PL- Consultation- Ecology (Biodiversity Net Gain) response

From: Jonathan Best <Jonathan.Best@arun.gov.uk>
Sent: 20 April 2026 10:48
To: Planning.Responses <Planning.Responses@arun.gov.uk>
Cc: Hebe Smith <Hebe.Smith@arun.gov.uk>
Subject: CM/4/26/PL

Rigates Climping Street Climping BN17 5RQ.

I have reviewed this application with regards to ecology and Biodiversity Net Gain.

Project	Rigates, Climping Street, Littlehampton
Drawing	Tree Protection Plan
Date	12.02.26
Ref	25-2053-TPP
Drawn	NT
Checked	DR
Client	Savills
Scale	1:500@A2

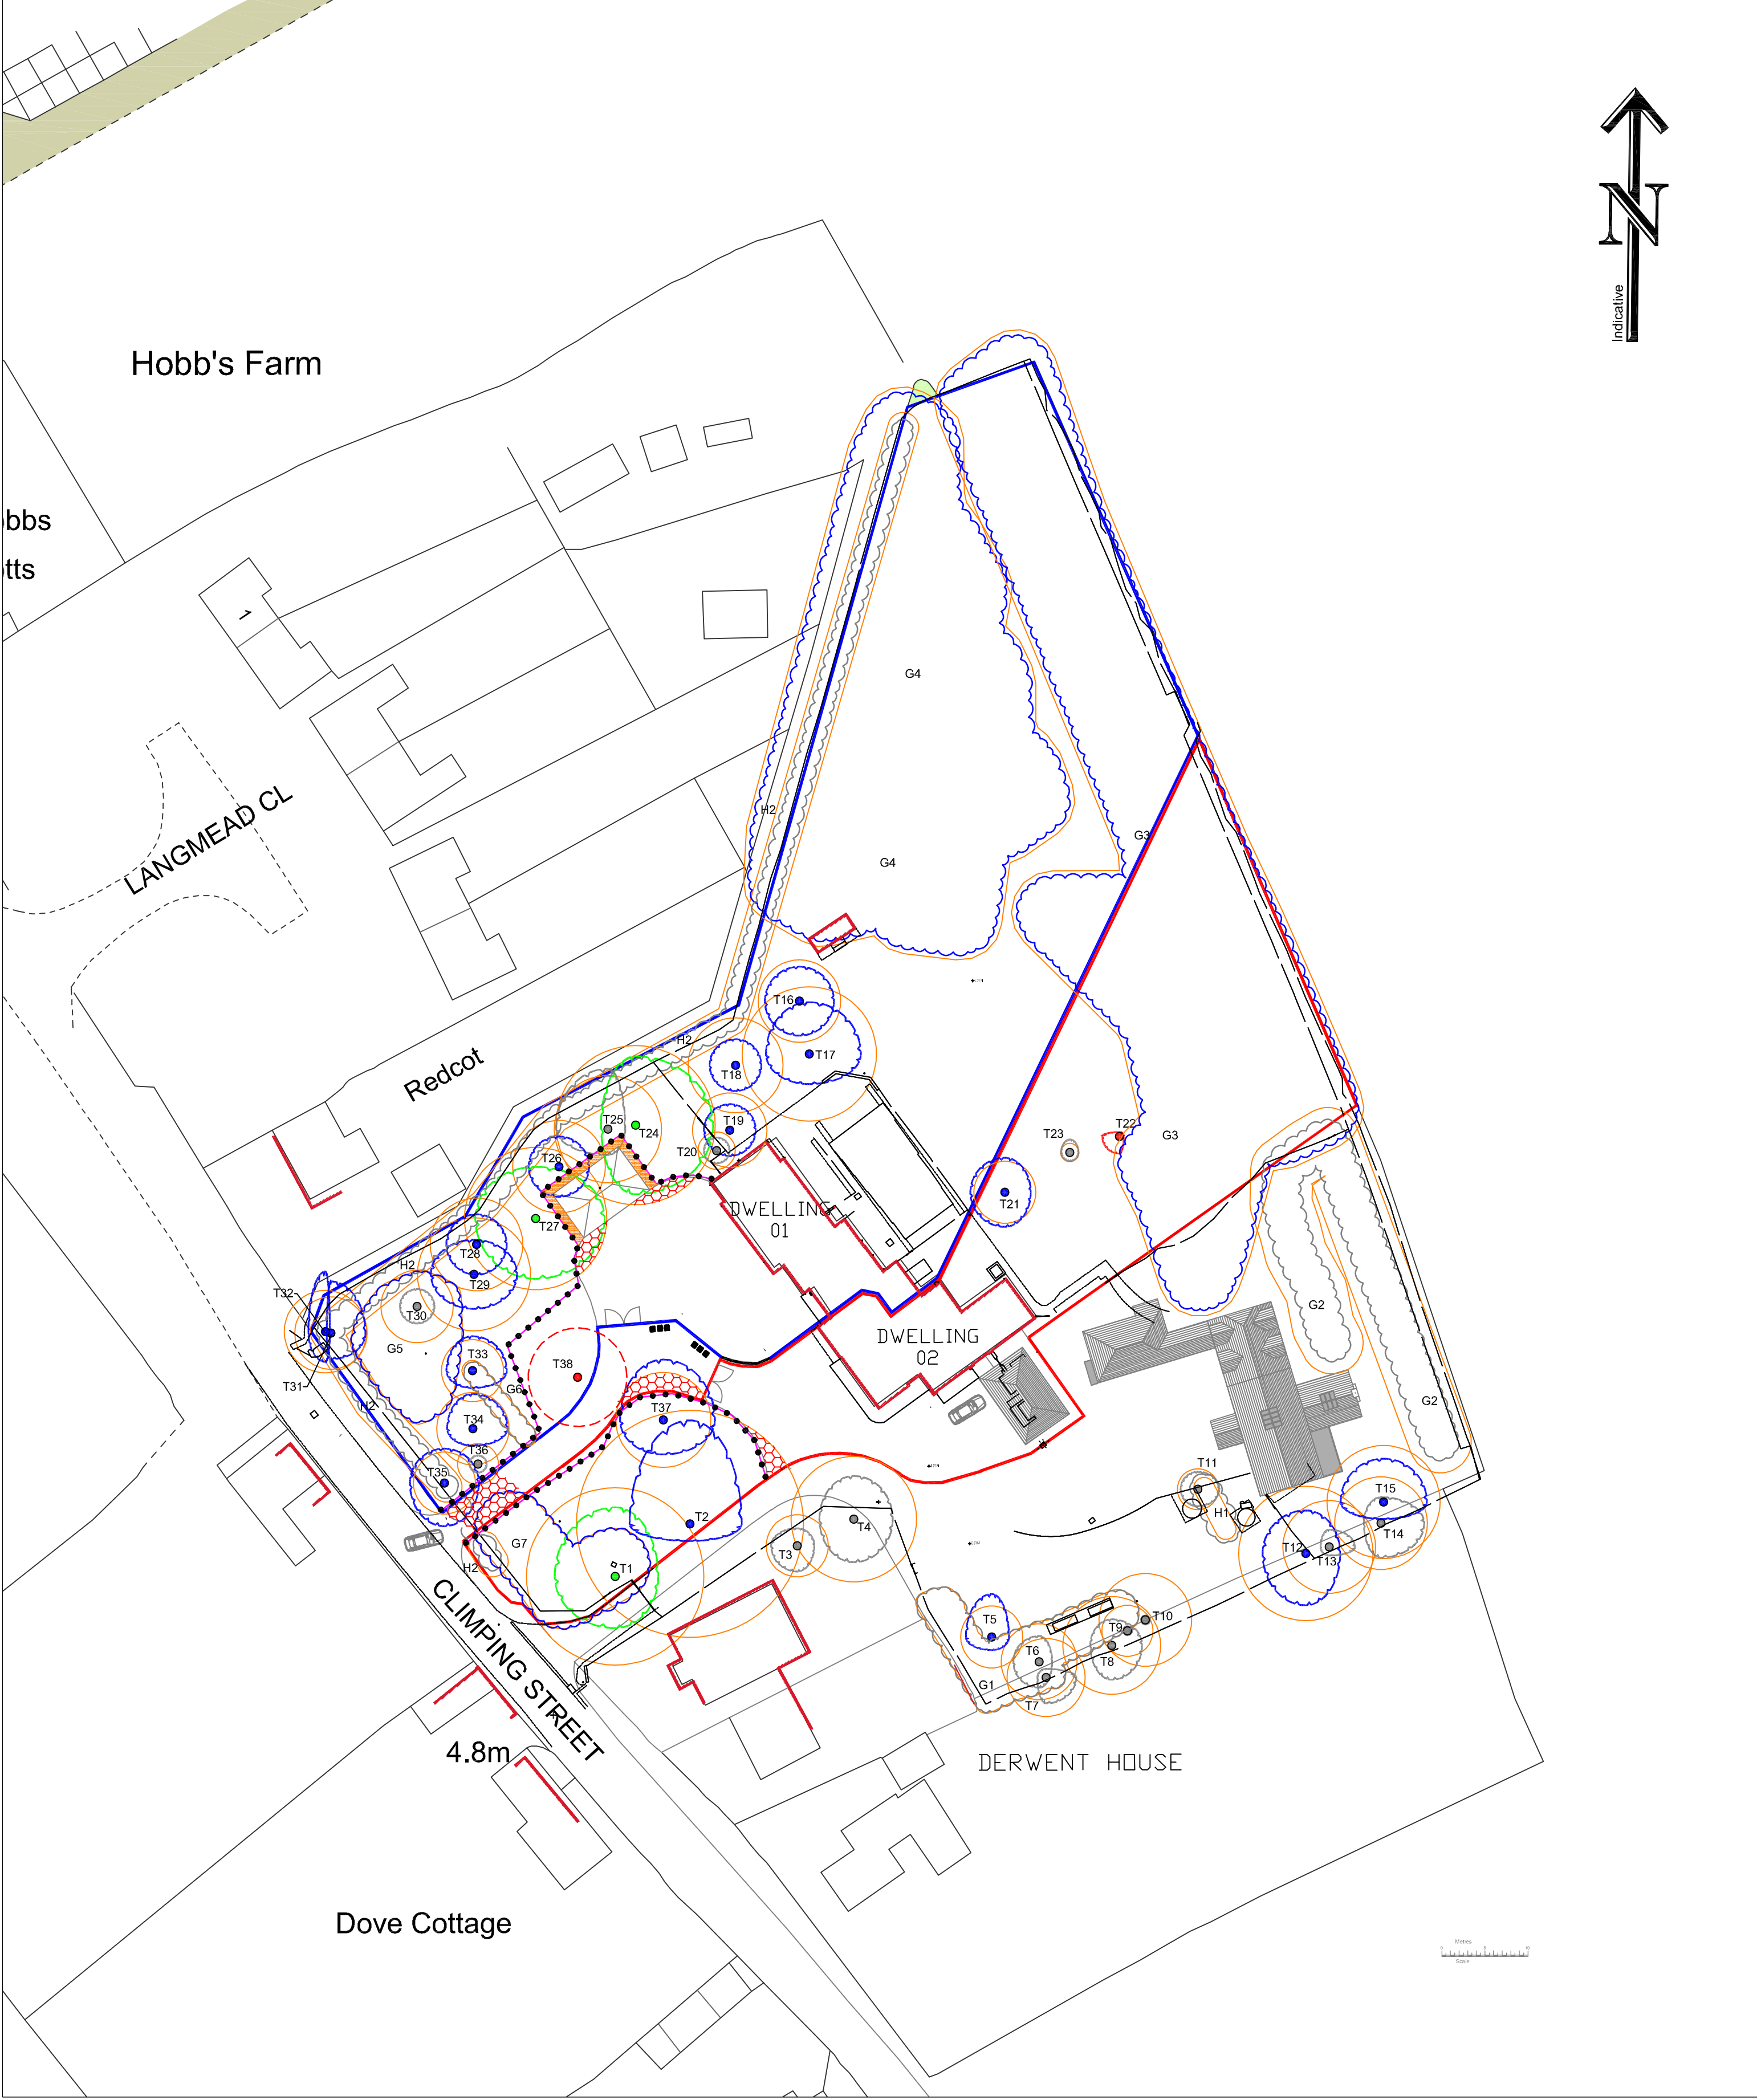
Tree T38 proposed for removal was considered to have PRF-I roosting suitability, since the identified features are considered suitable only for opportunistic use by individual bats Therefore, as a precautionary measure, an endoscope inspection immediately prior to removal will be required, followed by soft felling under supervision by a licensed ecologist.
